## City of Albuquerque Stormwater Construction Site Inspection Report

Project Name and Location	Aztec Special Education Facility Eubank and Lexington		
Site Contact Name & Agency	Annette Darby APS	Contact Phone #/ E-mail	505 848-8829
Date of Inspection	4-4-17	Start/End Time	11:00/11:00
Inspector Name, COA Dept.	Curtis Cherne, Stormwater Quality		
Inspector Phone / E-mail	505-924-3420/ccherne@cabq.gov		
Inspector Qualifications	Qualified Compliance Inspector of Stormwater- Stormwater One		
Describe Present Phase of Construction	Stabilized		
Type of Inspection:			
<input checked="" type="radio"/> Regular    • During storm event    • Post-storm event (> 0.5 inch)    • 311 / Complaint Response    • Follow-Up

**From:** Cherne, Curtis  
**Sent:** Wednesday, February 24, 2016 4:31 PM  
**To:** 'annelle.darby@aps.edu'  
**Cc:** Jeffrey G. Mortensen  
**Subject:** Aztec Special Education Facility SWPPP inspection  
**Attachments:** east\_entrance.jpg; Eubank\_track\_out.jpg; Lexington\_track\_out.jpg; north\_no\_stabilized\_entrance-.jpg

ESC-102

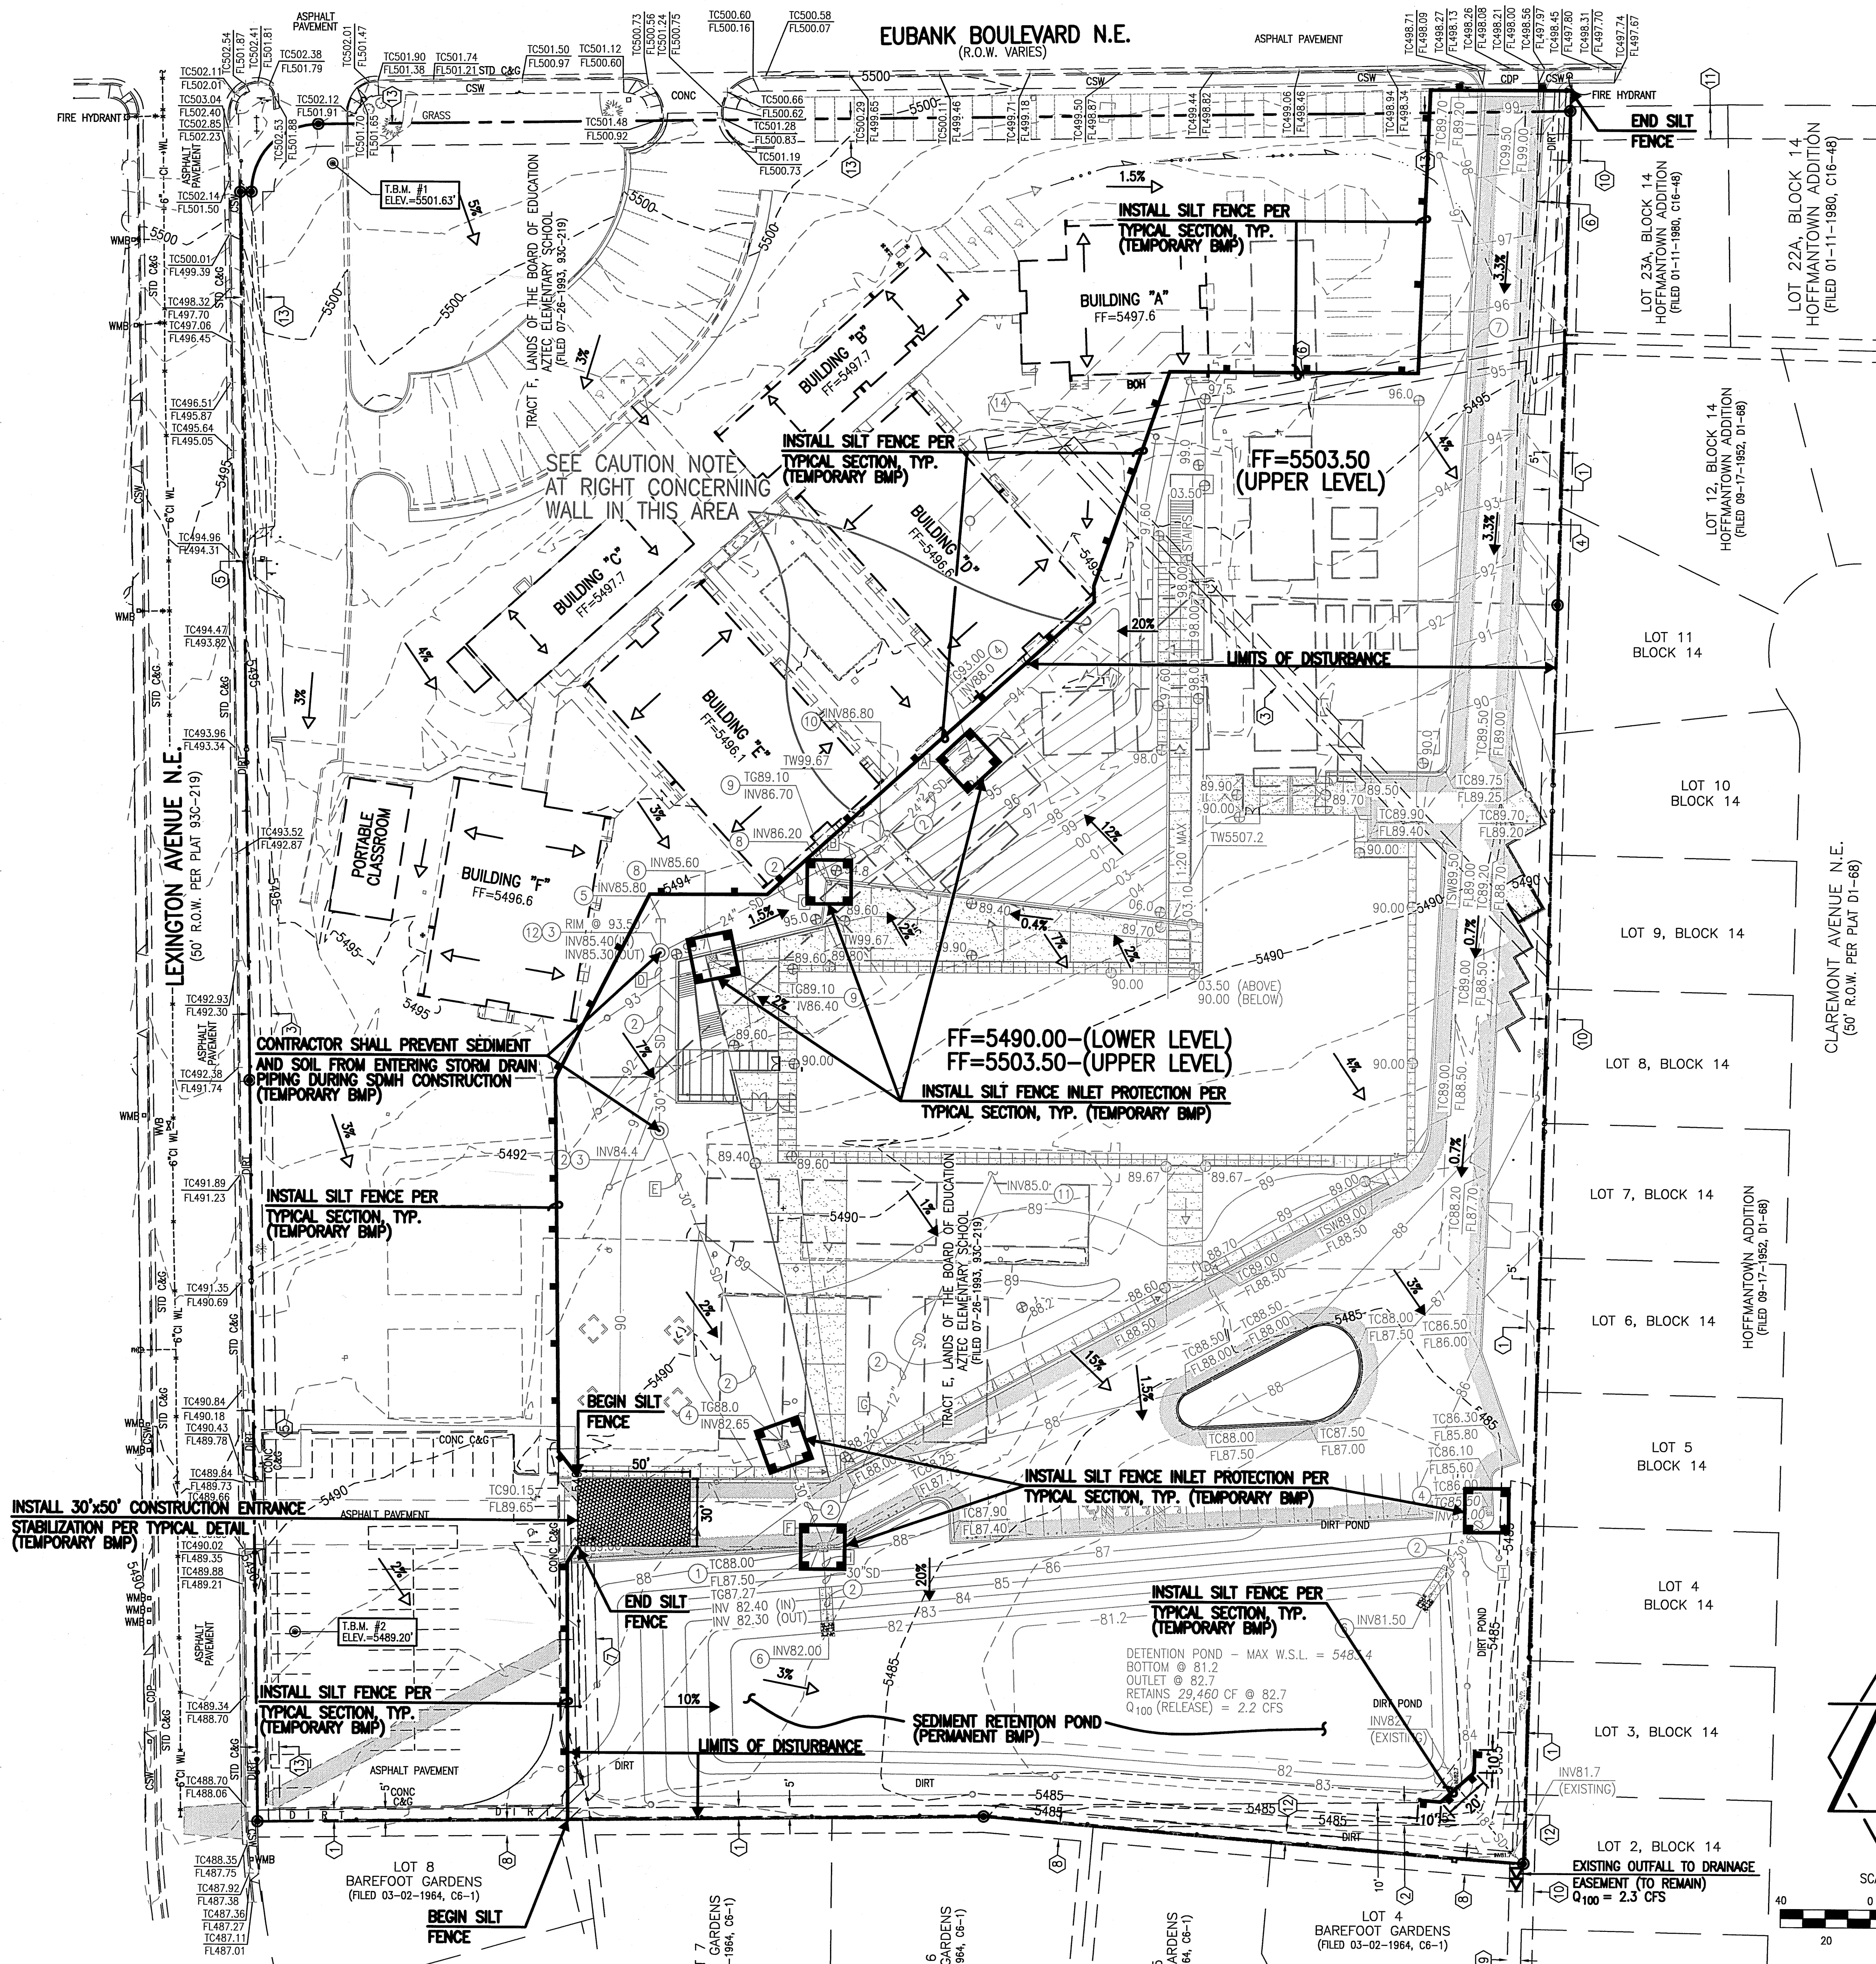
1. Track out onto Eubank and on sidewalk. The engineer does not show an entrance onto Eubank on his ESC plan. Most likely you will be building a road here soon. Consider closing this construction entrance.
2. The north entrance onto Lexington does not have a stabilized entrance. Most likely reason for heavy track out. Track-out extends nearly to Eubank.
3. Sediment is in gutter pan from north entrance to west property line.

1. Sweep Eubank Blvd and sidewalk. Sediment goes down Eubank in the gutter for a 100 feet or so. Close or improve stabilized entrance it is full of muck.
2. Sweep Lexington.
3. Install stabilized construction entrance per approved ESC plan.
4. I didn't see that the site was posted per paragraph 1.5 of the CGP.
